19 October 2018

Our Reference: SYD18/00146/02 (A24473610)  
DPE Ref: SSD 9036

**CONCORD REPATRIATION GENERAL HOSPITAL REDEVELOPMENT (CONCEPT AND STAGE 1)  
1H HOSPITAL ROAD, CONCORD WEST**

STAGE 4 HOSPITAL RD ROUNDABOUT

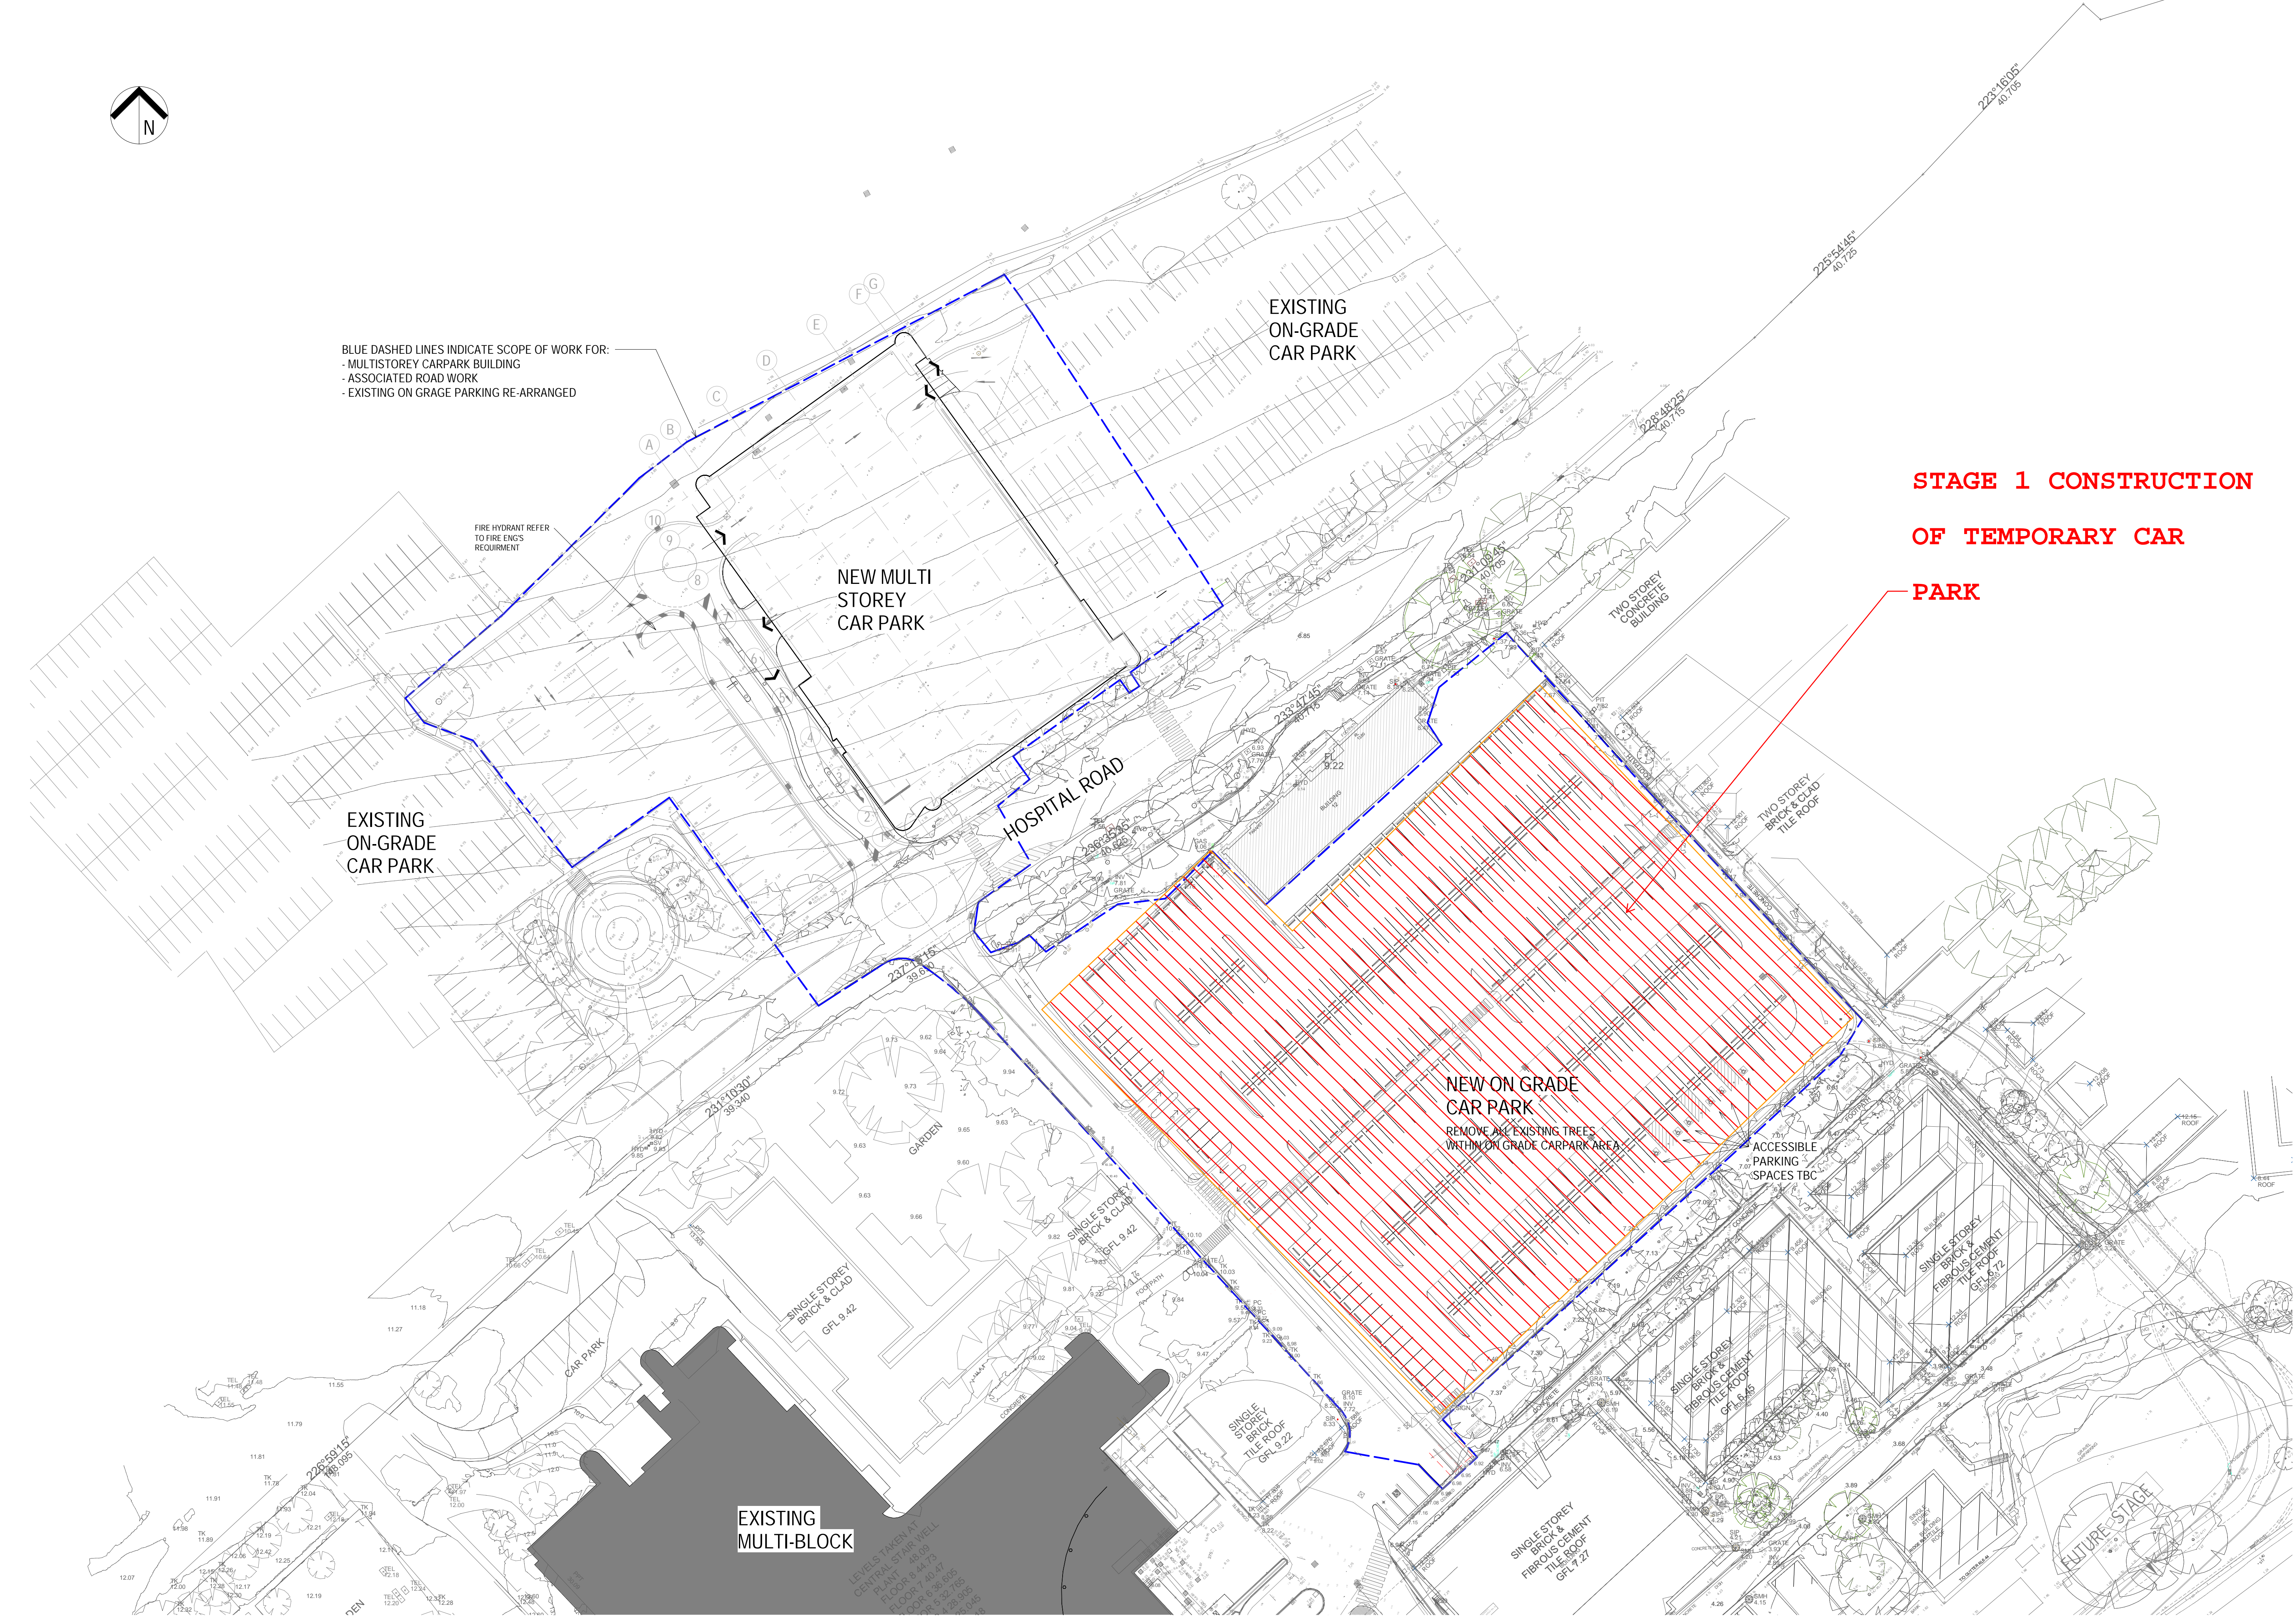
2. Roads and Maritime recommend that an independent Road Safety Audit (RSA) is conducted on the final design on the treatment and upgrades to Hospital Road.
3. The design of new roundabouts should be designed in accordance with Austroads Guide to Road Design Part 4B: Roundabouts Section 4.3.3 (2015), Roads and Maritime notes that the current design currently is inconsistent with the guide.
